Ref: Planning Application: AW/129/18/HH

**OBJECTION TO PLANNING PERMISSION – 20 ALDWICK GARDENS
APPLICATION: AW/129/18/HH**

Proposed West Elevation

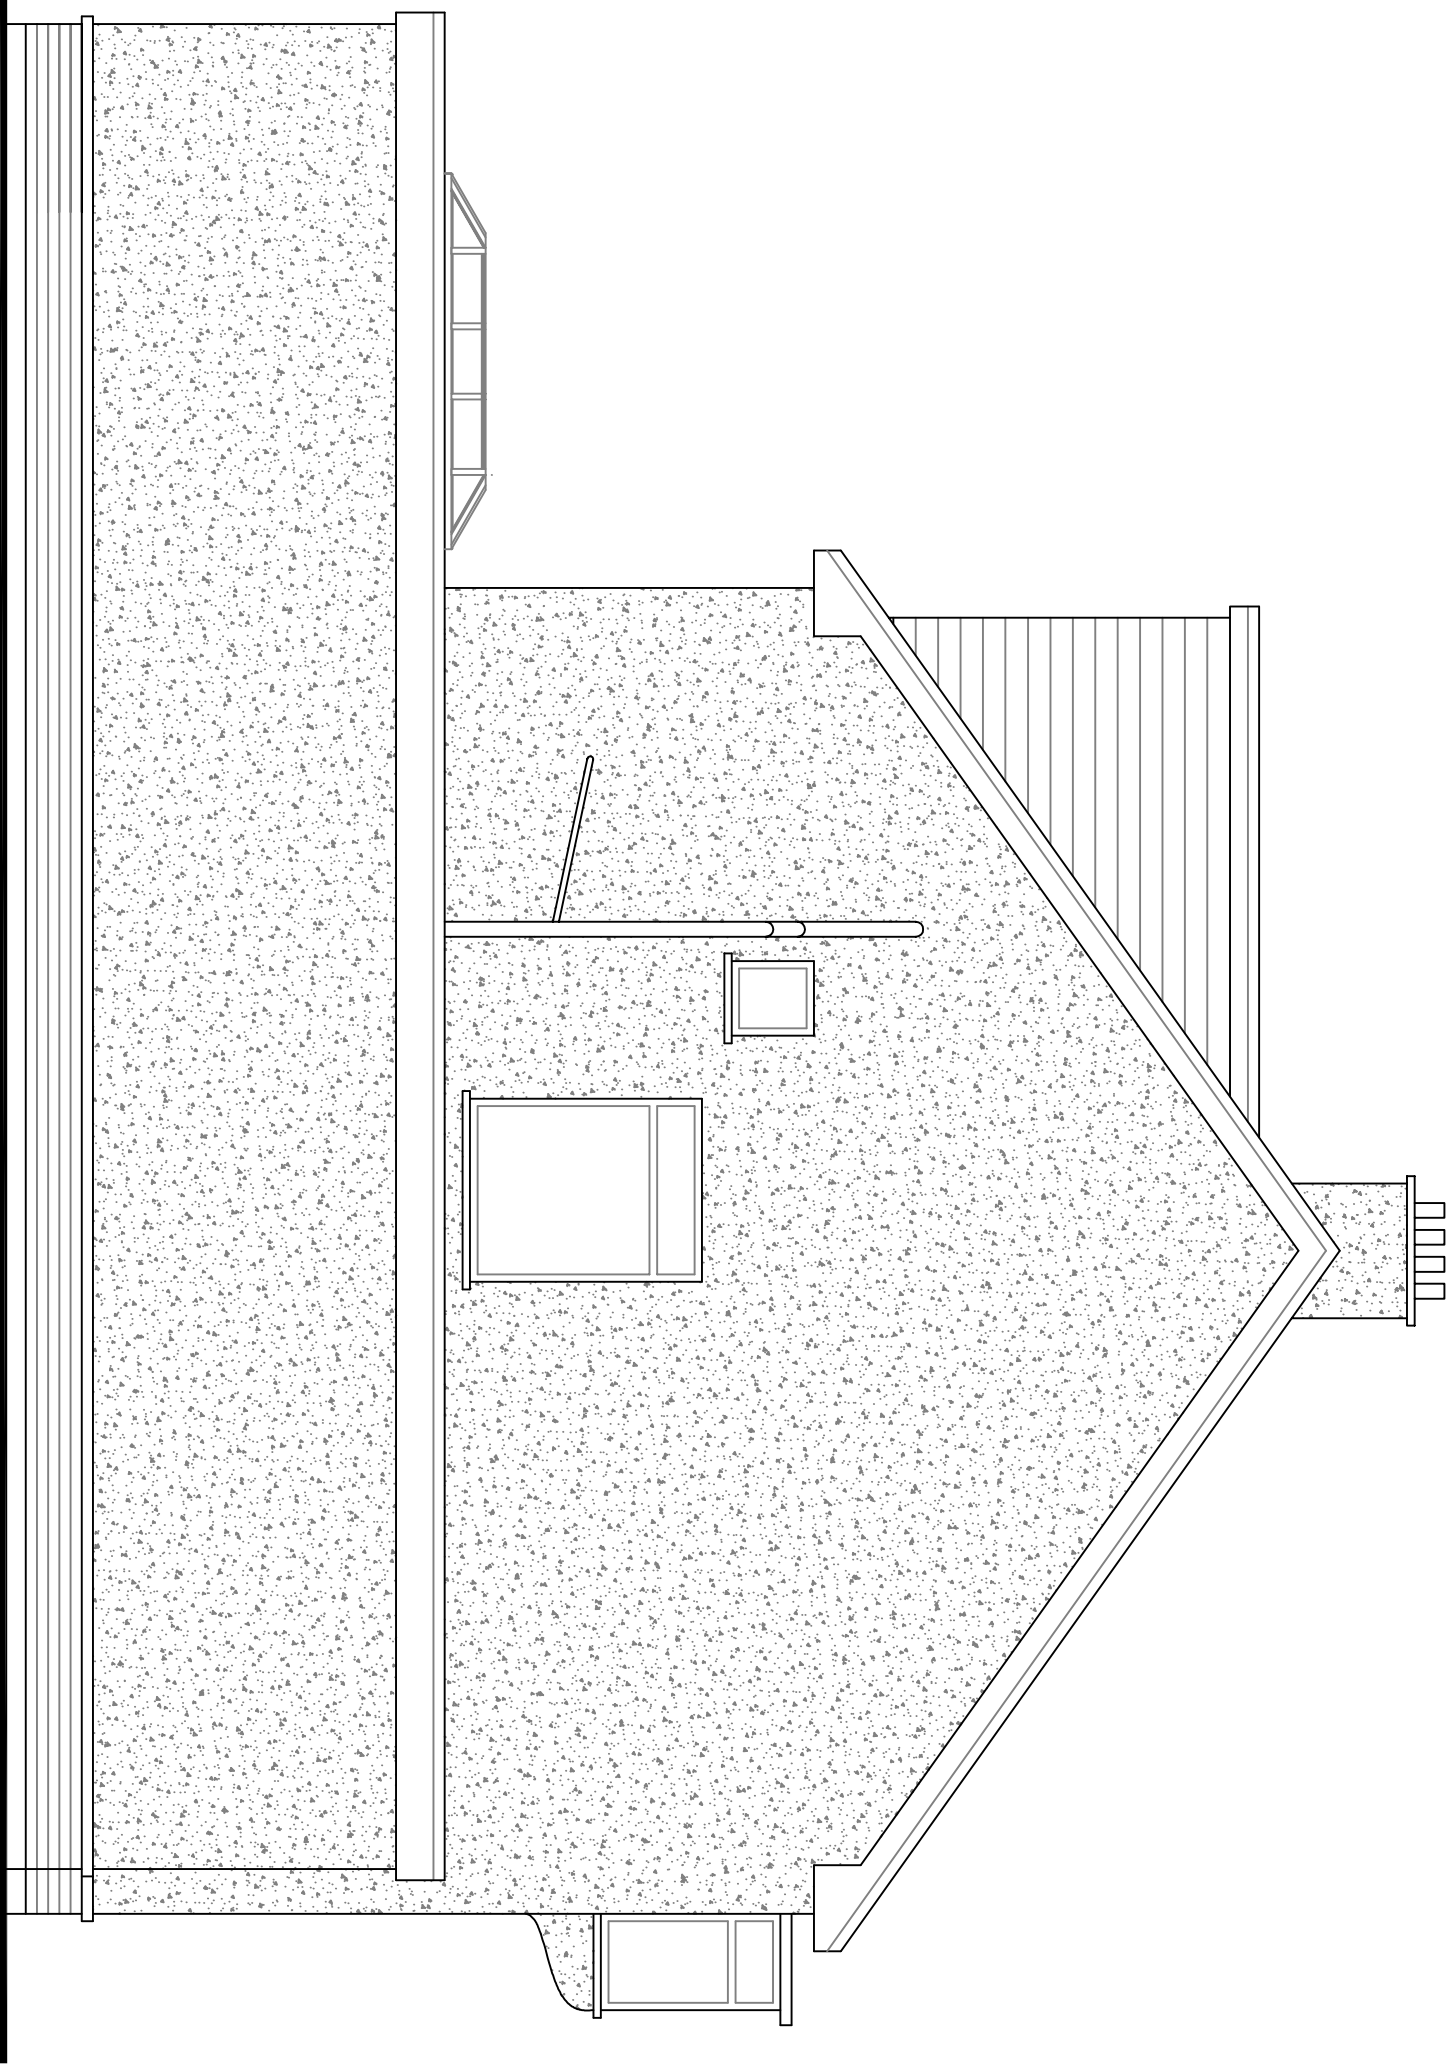
The house is at present a fairly attractive semi-detached with a standard pitched tiled roof. The proposed loft conversion will effectively make it a 3-story building as the plans show a squared off box type roof structure which looks as if it overhangs the side of the building. This proposed new roof in our opinion is completely out of character to the type of roof that exists on properties in this road, namely pitched.

As owners of the bungalow next door (no 22), the new construction will tower over our home and garden, invading our privacy and also restricting sunlight at times of the year.

Proposed Ground Floor Plan

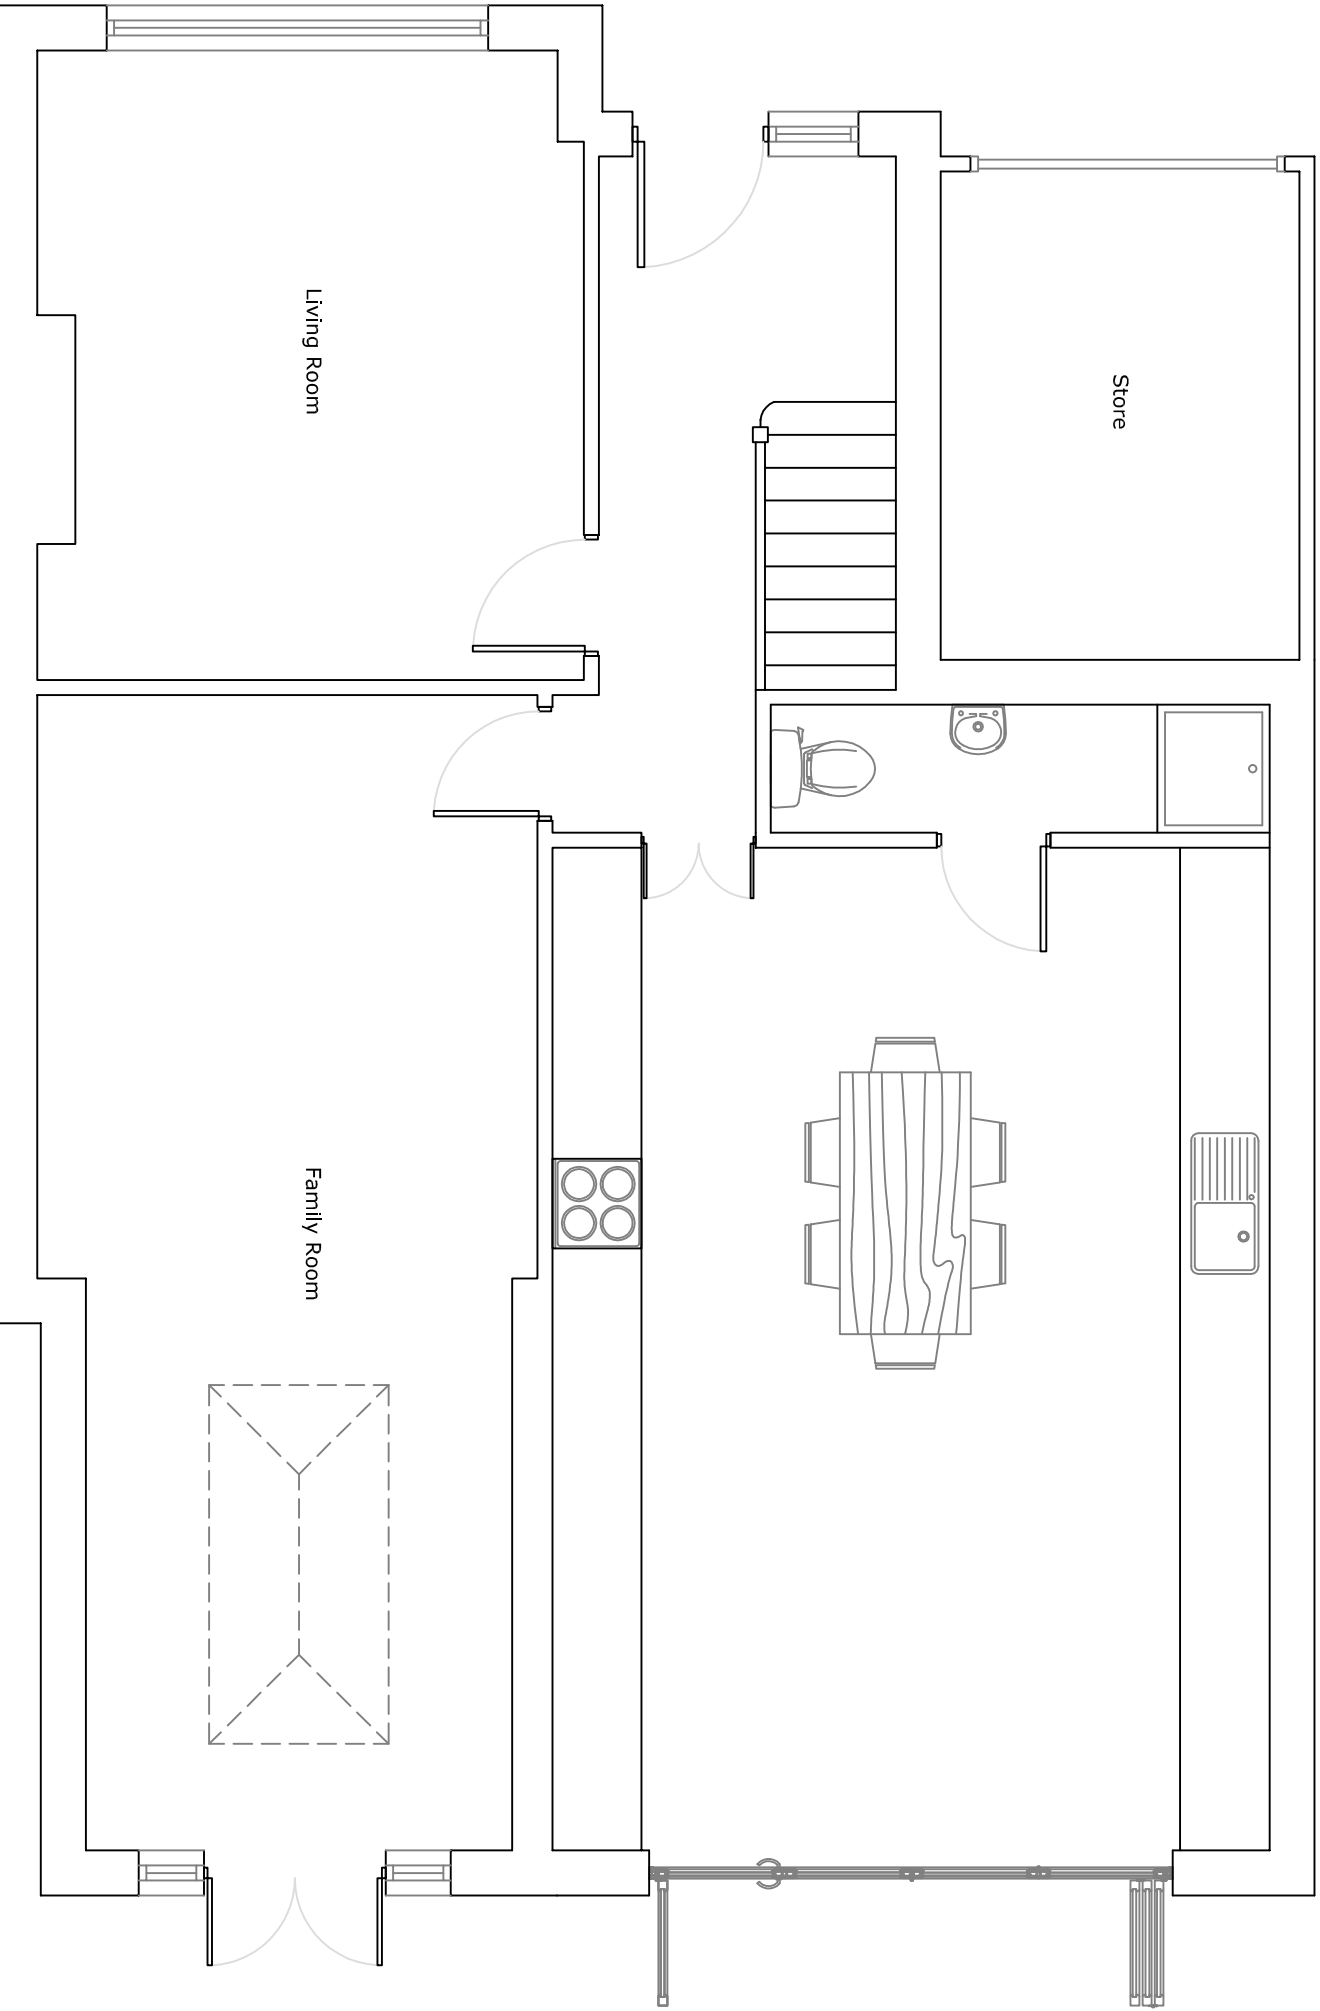
The proposed new ground floor extension will wrap around the whole of the ground floor extending out to the border of our property. The extension includes double bi-fold doors to the garden which will be right next to our property and so any noise inside their house will be exacerbated. The proposed ground floor extension will hugely increase the square footage of what should be a semi-detached house.
